**AMERICAN TOWER®**  
CORPORATION

## Structural Analysis Report

**Structure** : 190 ft Self Support Tower

**ATC Asset Name** : Black Forest

TOWER ELEVATION	
SHEET NUMBER: C-201	REVISION: 0

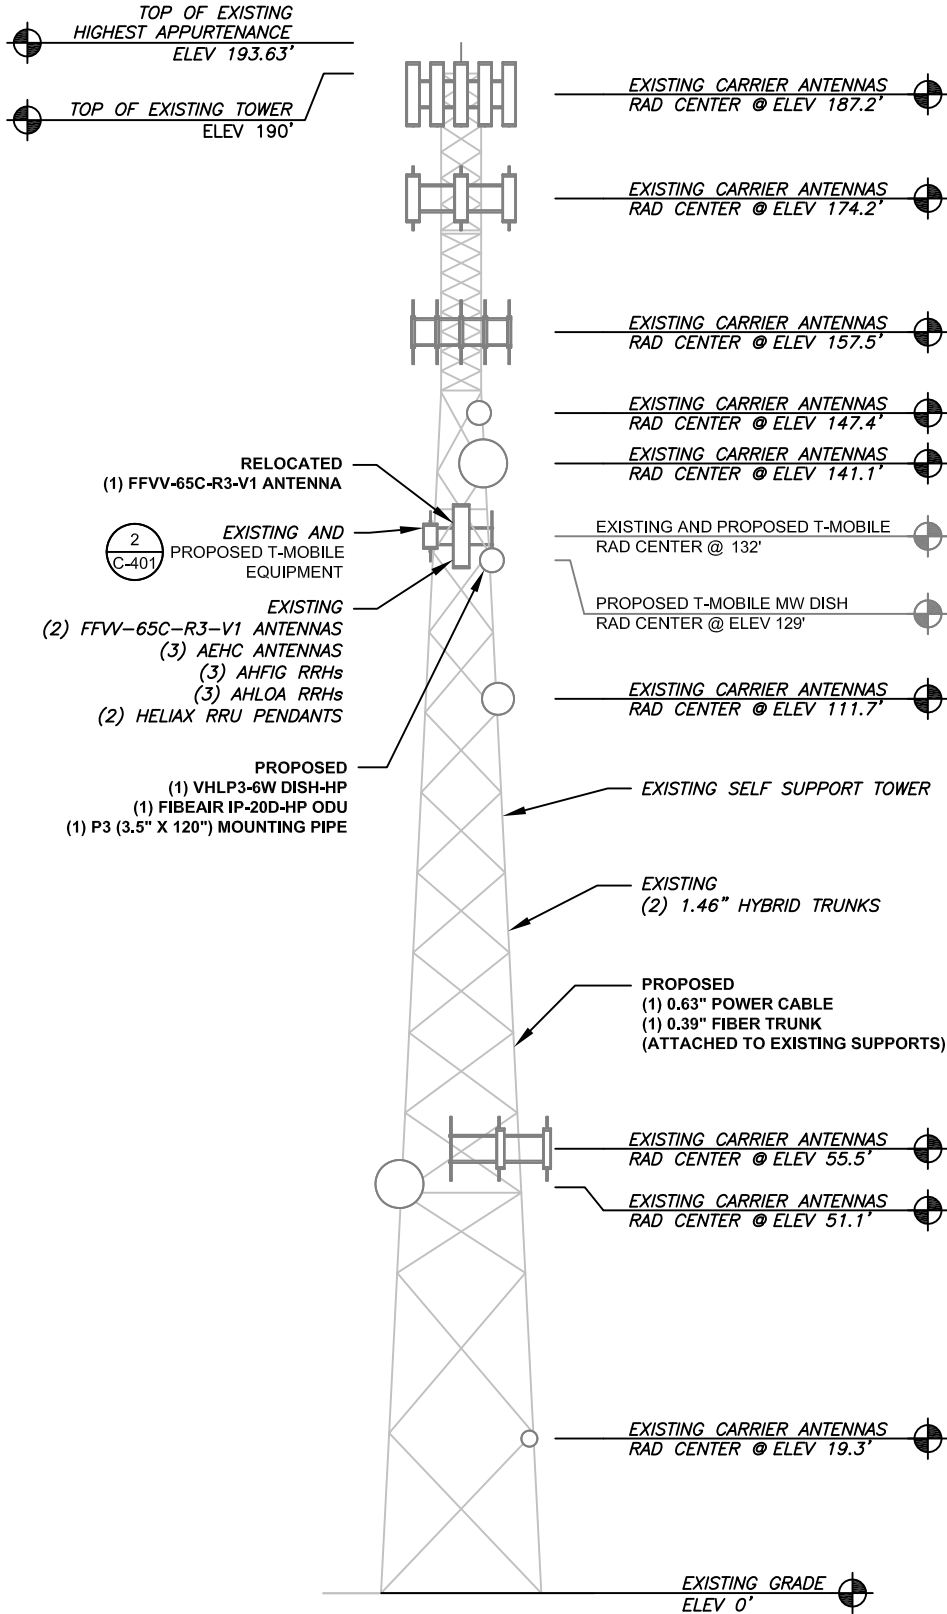
This is not an elevation drawing. Please submit the same document you submitted with the first submittal.
